Welwyn Hatfield Borough Council

Application for a non-material amendment following a grant of planning permission.

job no. + work stage + building + drawing no. **2142 / 03 / 0010** revision **-**

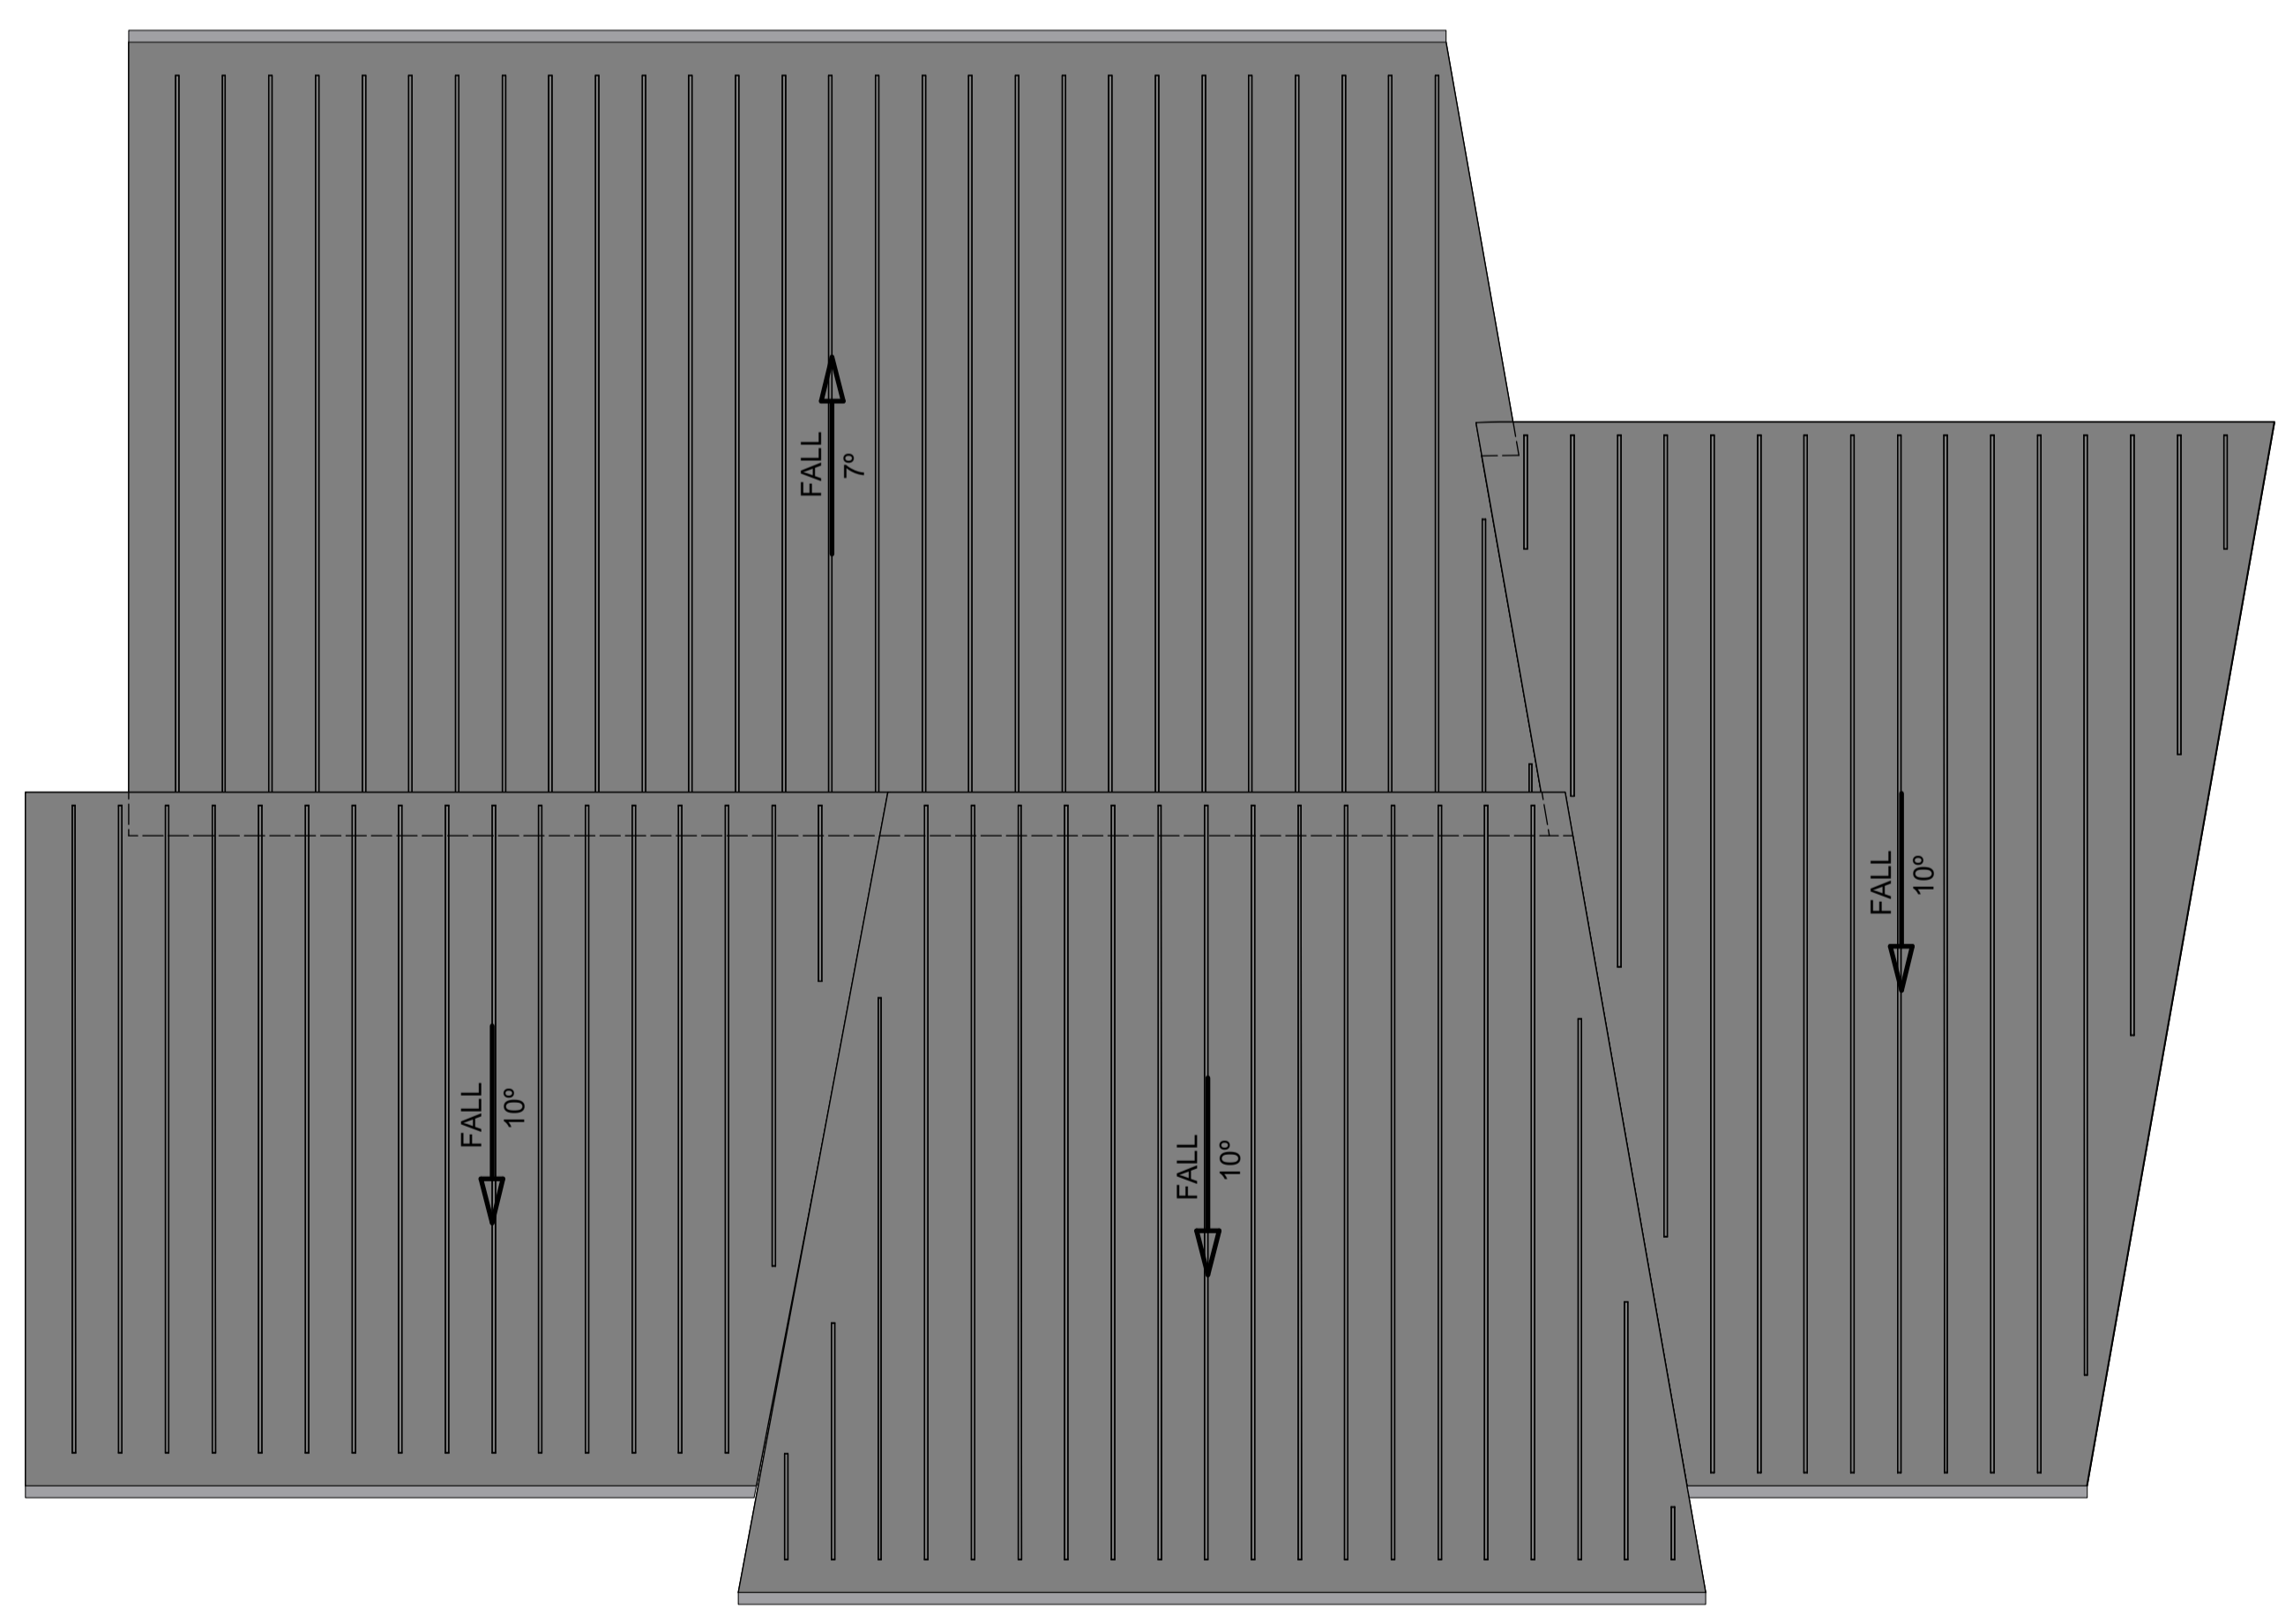
Internal alterations with associated changes to fenestration and roof profiles. Rationalisation of external materials.

Delay in obtaining funding and changes in school leadership team have led to value engineering to rationalise room heights and roof profiles, resulting in a reduced overall building height, together with internal alterations to better reflect current and future needs. Resultant changes in room layout and roof profiles has led to minor variations in external door and window configurations. Building location, footprint and occupancy remain unchanged from the approved drawings.

2142/03/0010B - Proposed Music Block Floor Plans  
2142/03/0015A - Proposed Music Block Elevations
